ADDENDUM

Date November 12, 2014

Re Addendum No. 1 to the Bidding Documents for:

USM
Central Heat Plant Boiler Upgrade
Portland, ME
Project No. 14411

M30.1

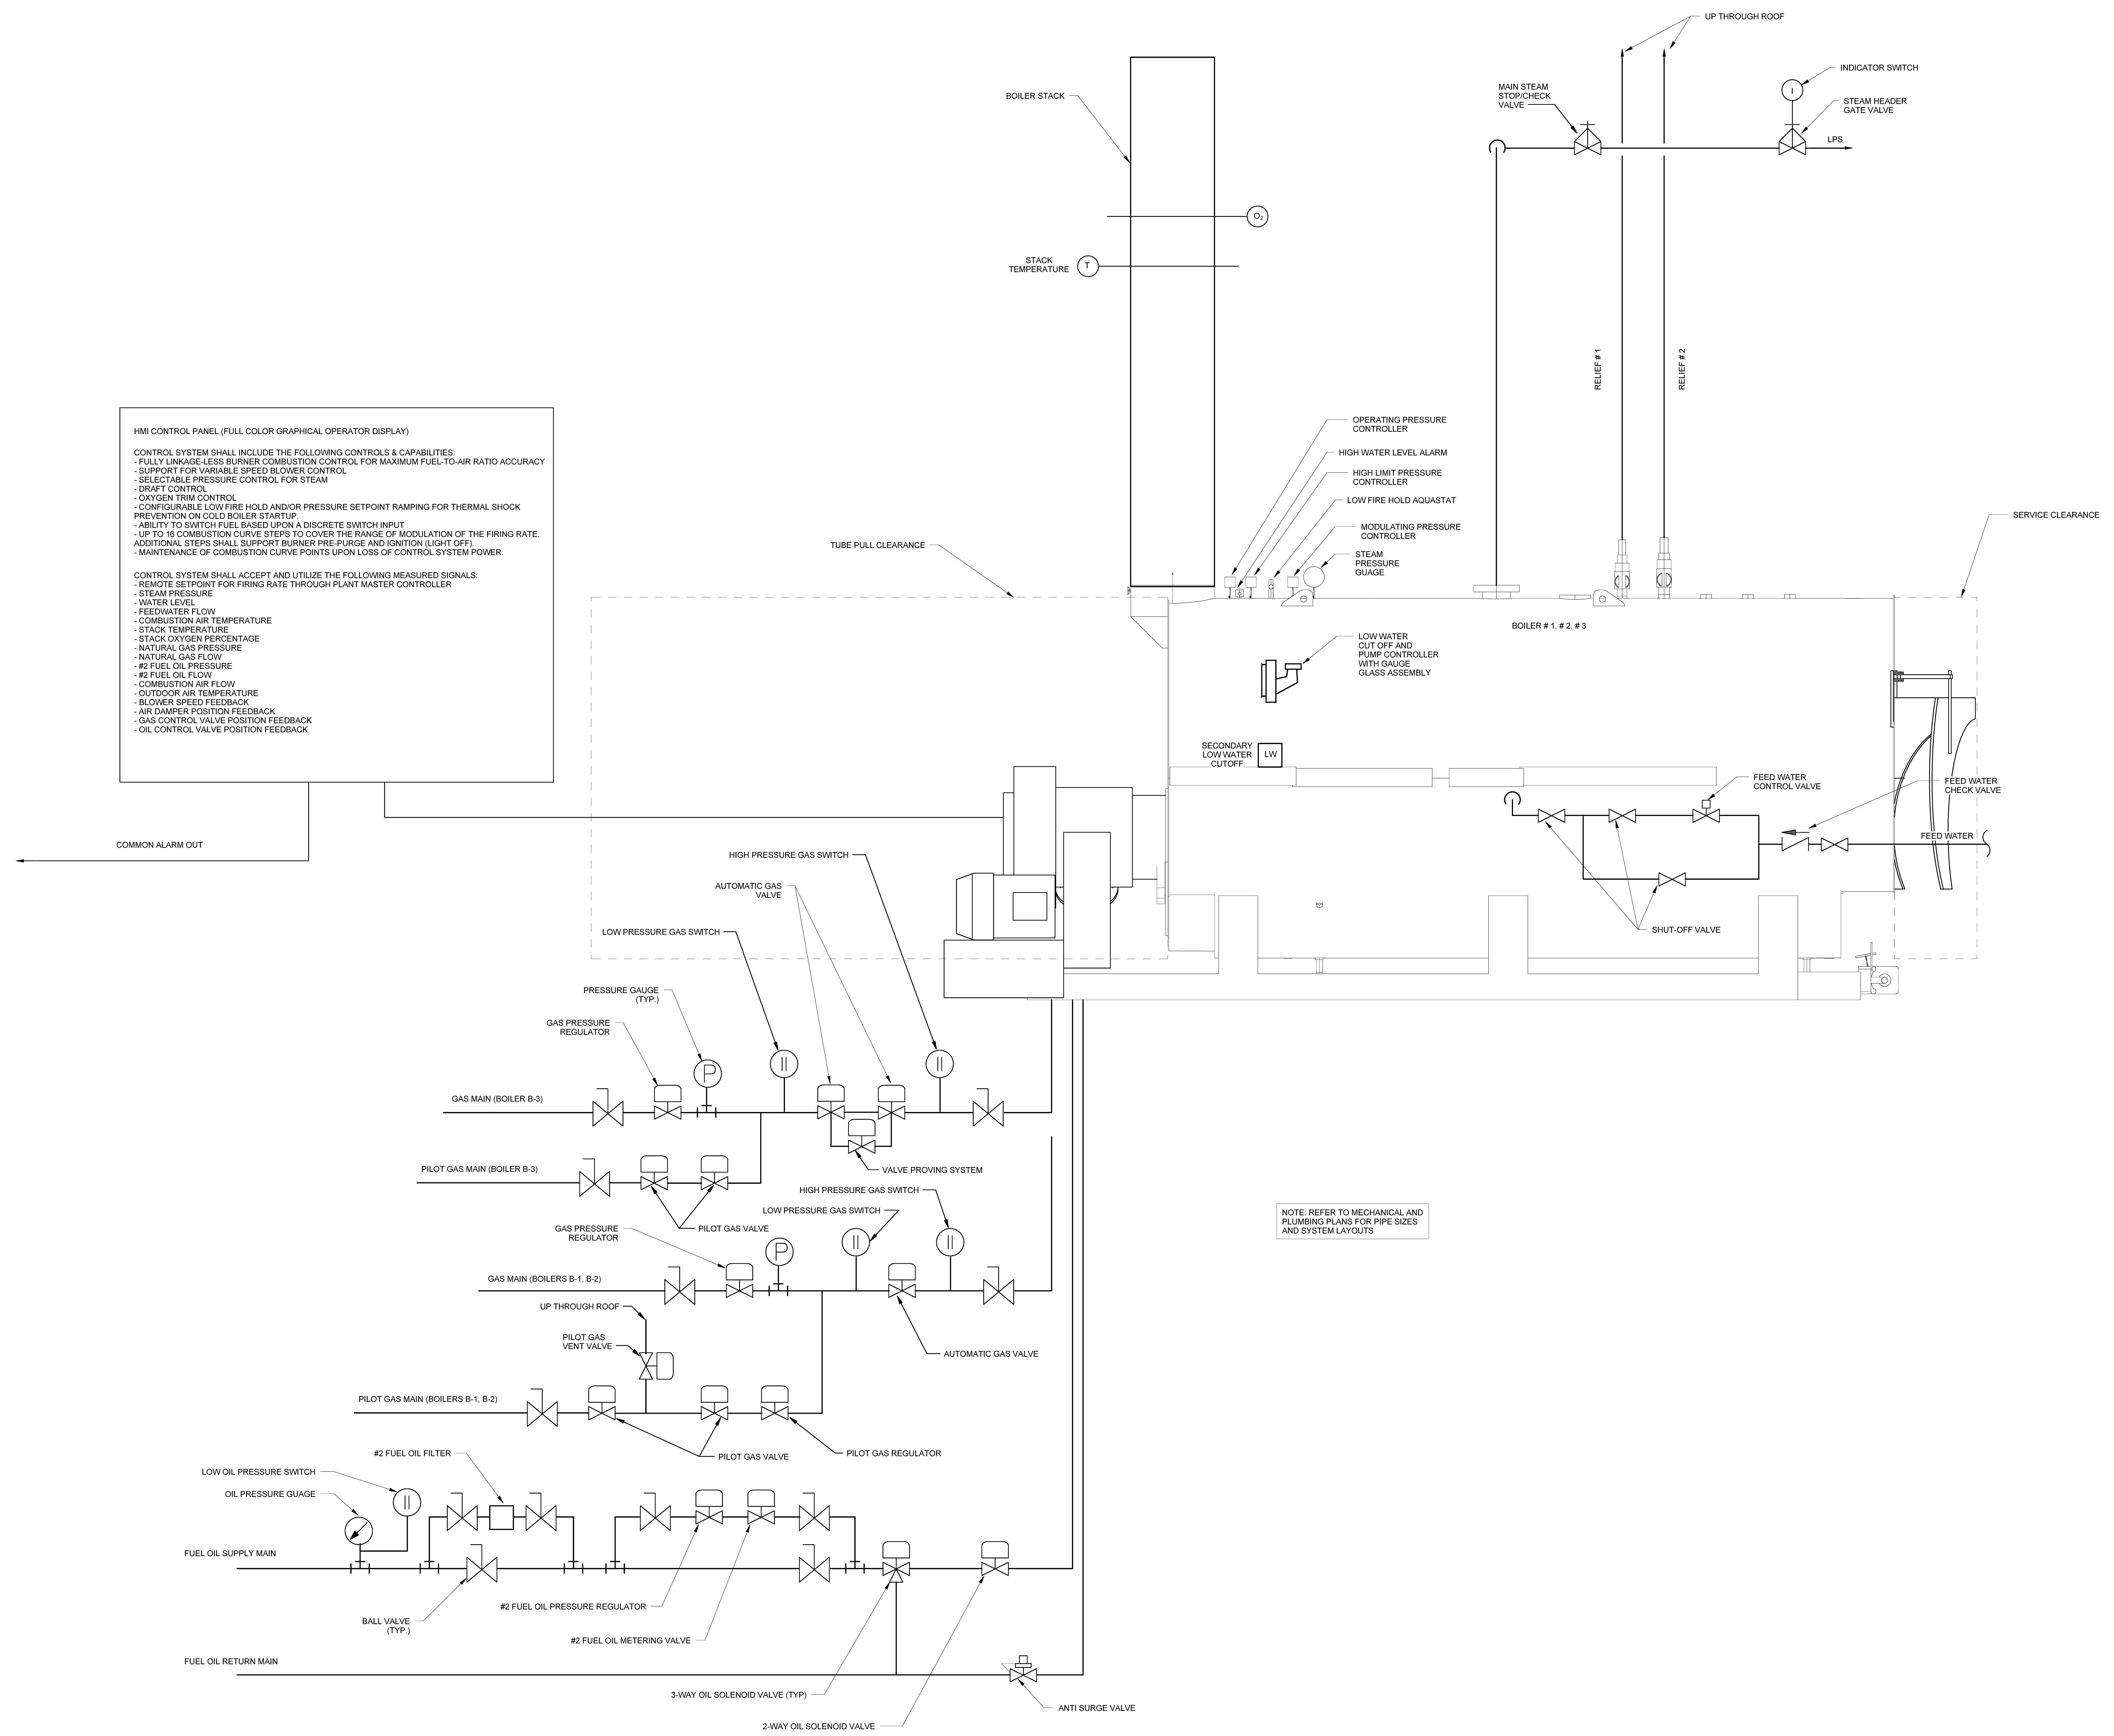
4. DRAWING M30.1 – TYPICAL BOILER SCHEMATIC DETAIL

- a. Remove the following from the drawing:
"Remove anti surge valve from fuel oil return line on typical boiler schematic detail."

POWER RISER DIAGRAM

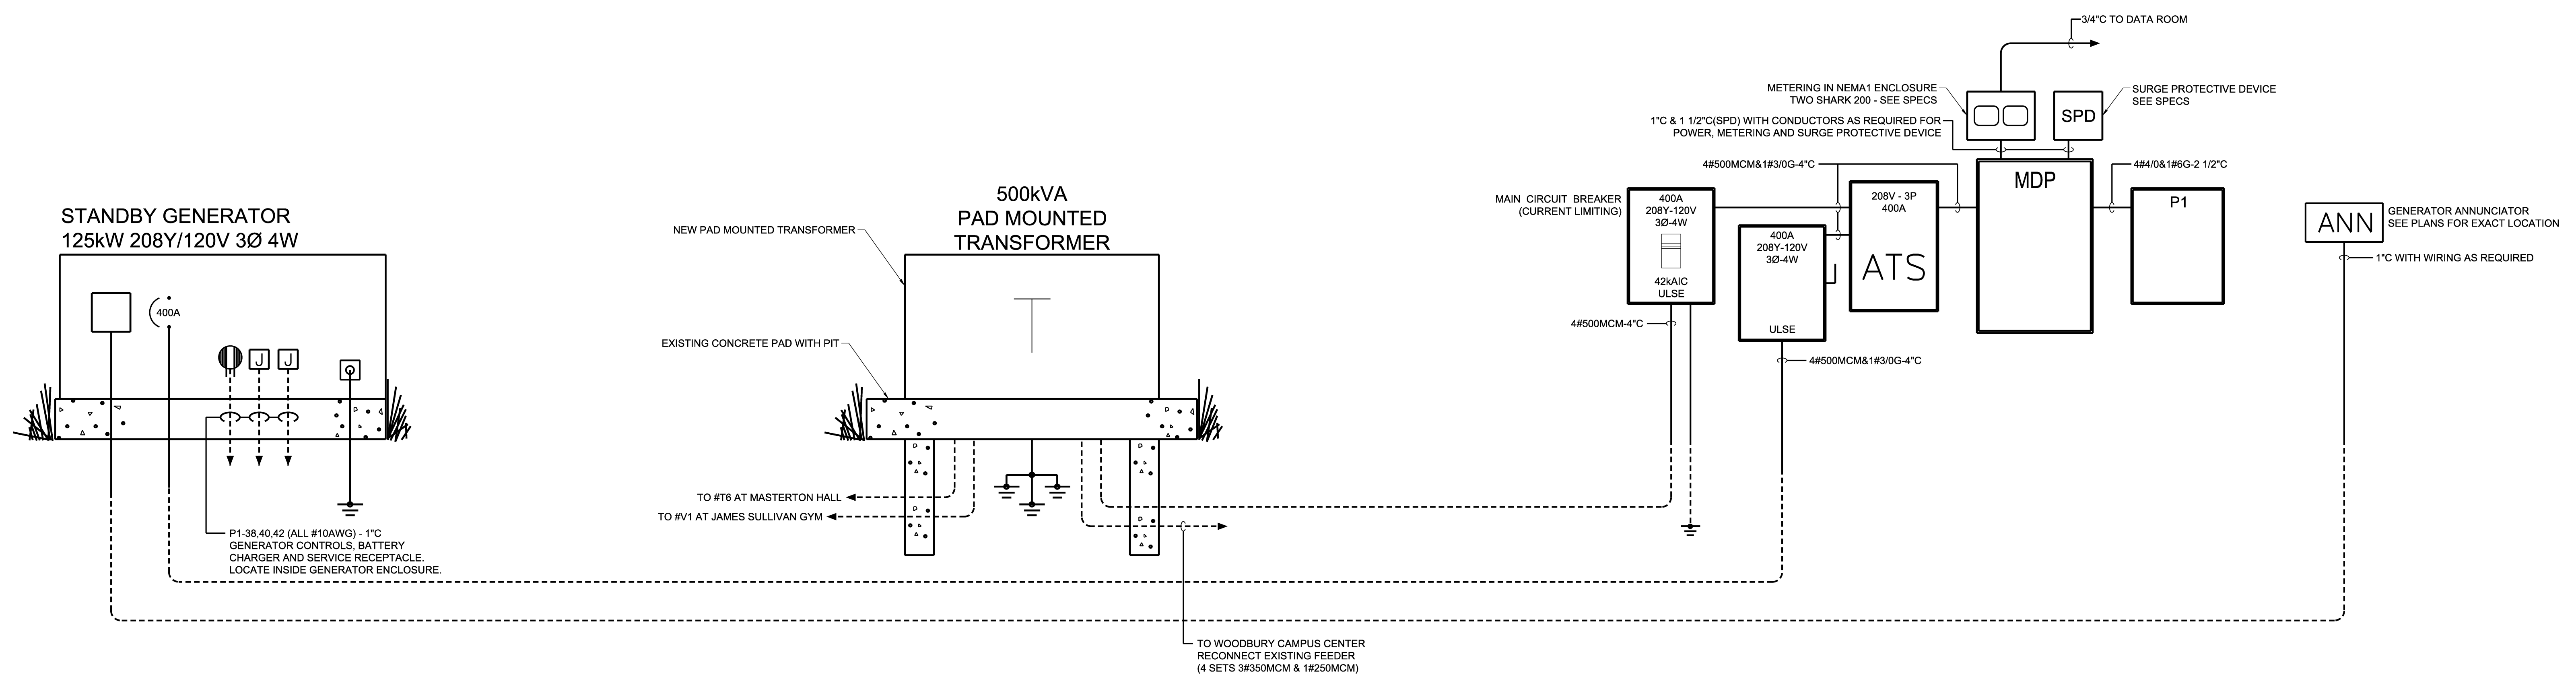
8. DRAWING E50.1 – RISER DIAGRAMS

- a. Add one 1" underground conduit from transformer pad to metering system enclosure at panel MDP for wiring required for Woodbury Campus Center feeder CTs. make all connections as required.
